# Rezoning Transportation Analysis

Petition Number: 2021-096

**Reviewer: David Smith, PE**  
David.B.Smith@charlottenc.gov  
704-336-4626

Revision Log:	Date	Description
	8-20-2021	First Review (DBS)

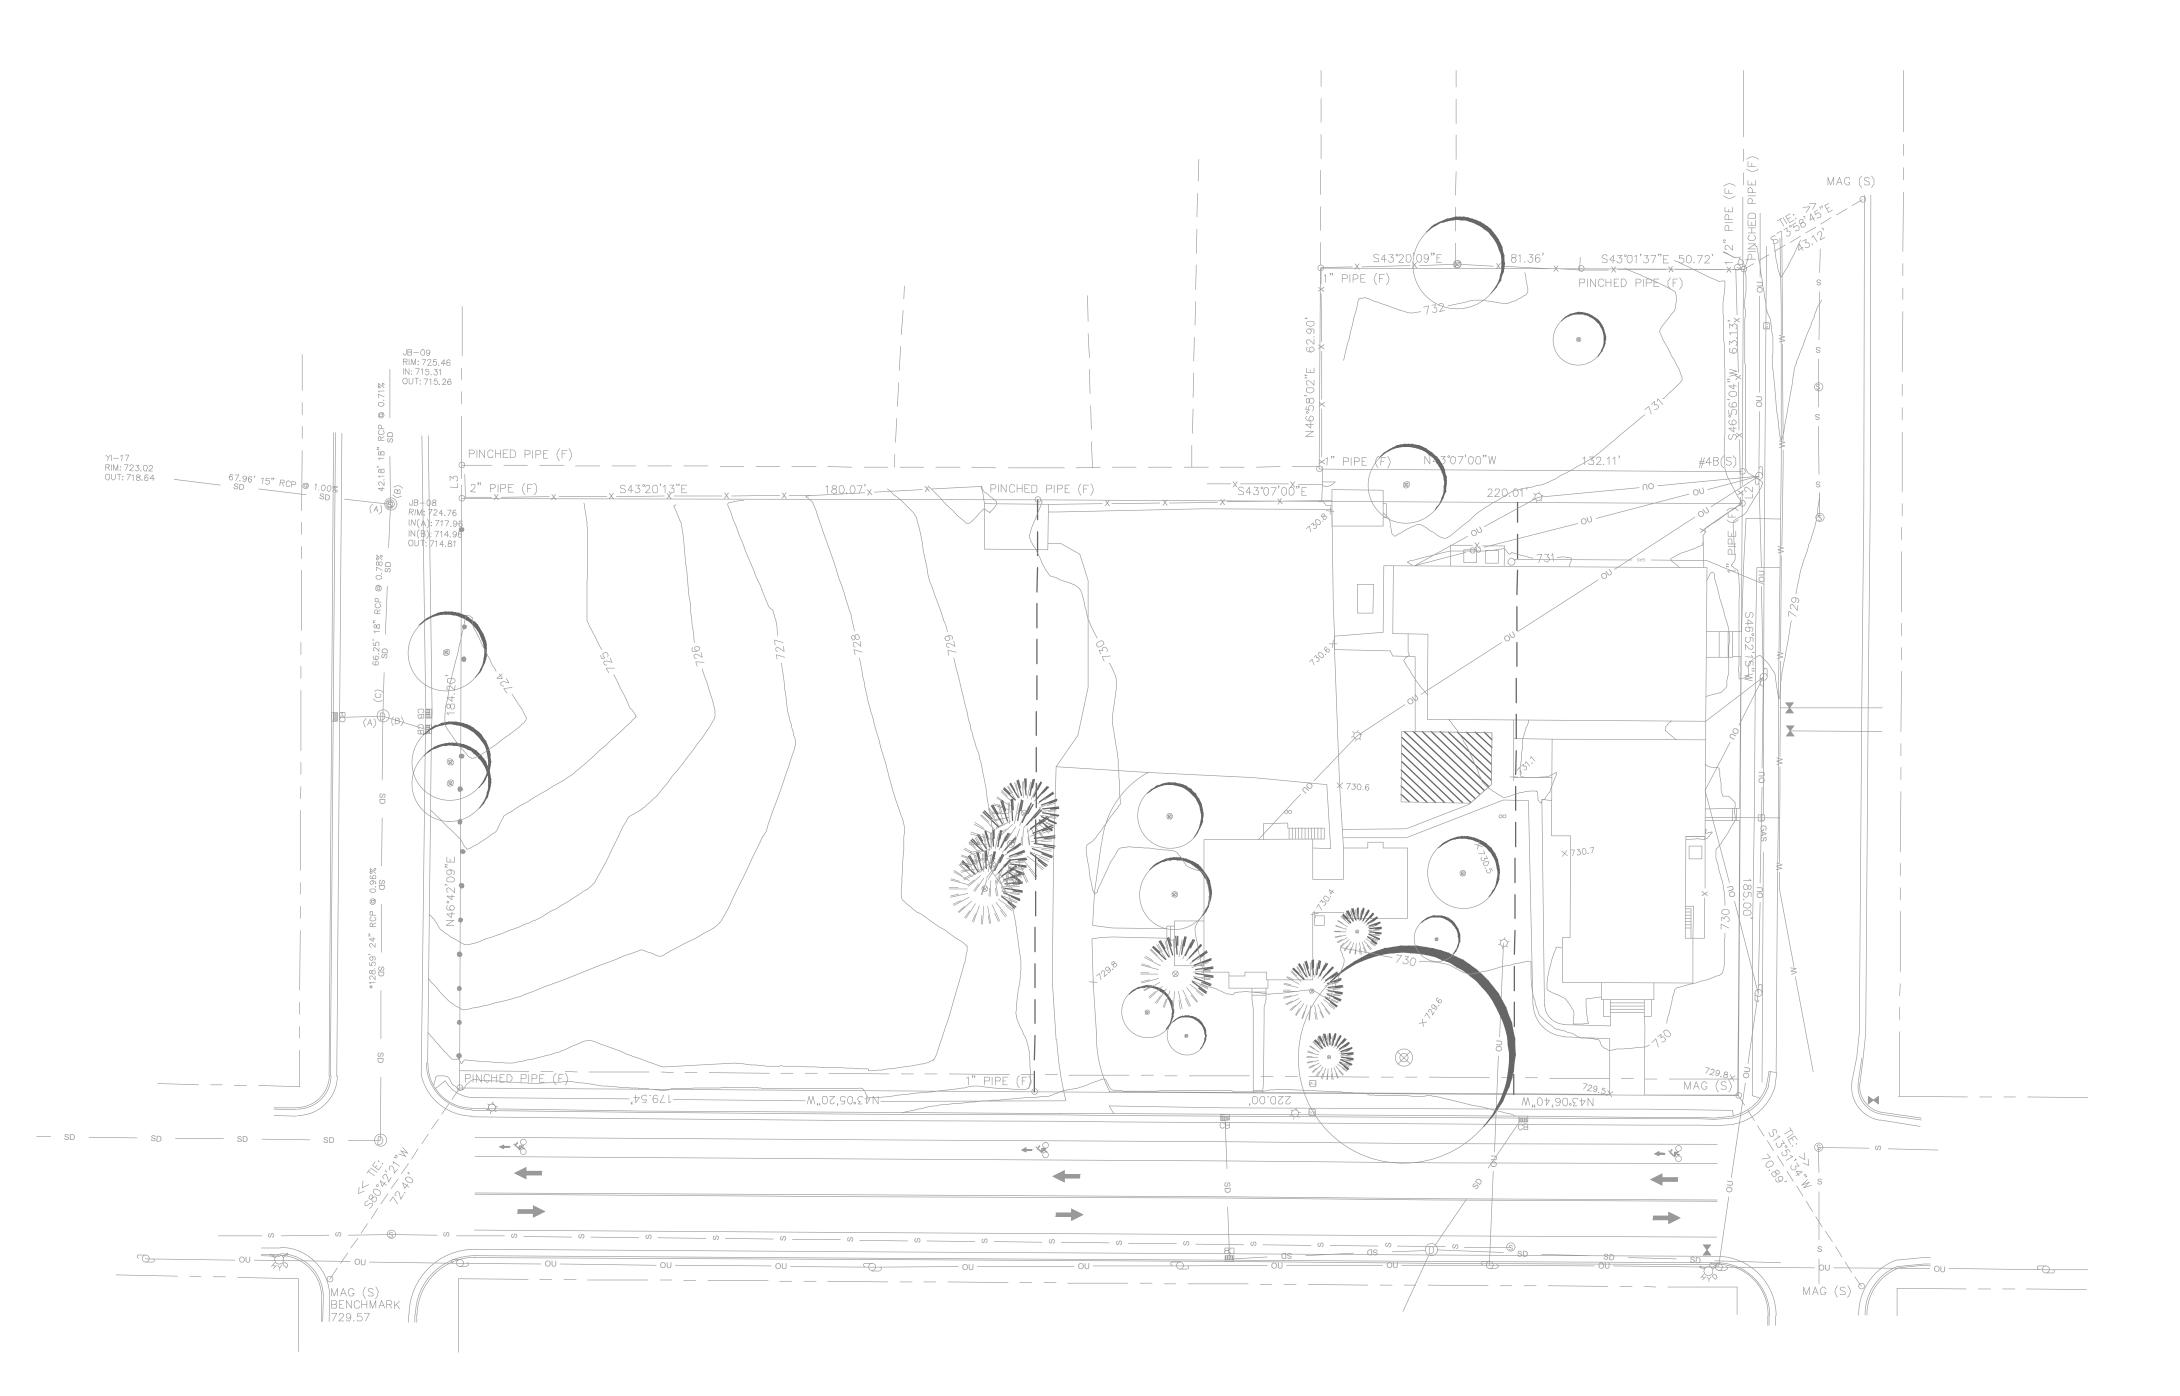
2. Revise site plan to reflect 10' x 10' sight triangles at the intersections of East 36<sup>th</sup> Street with North Alexander Street and North McDowell Street.

3. Revise site plan to indicate two curb ramps at the intersections of East 36<sup>th</sup> Street with North Alexander Street and North McDowell Street.

4. Revise site plan to indicate proposed access point(s).
5. Revise site plan to include dimensions of bike lane and on-street parking. Cross-section needs to be symmetrical from centerline street (bike lane and on-street parking on both sides)

6. The unused alley in the northwest corner of the site is for the benefit of all adjoining property owners and may not be planted unless it is formally abandoned.

7. Revise site plan to show replacing valley gutter on the North Alexander Street frontage with standard 2'6" curb and gutter to match the curb on the opposite side of North Alexander Street.
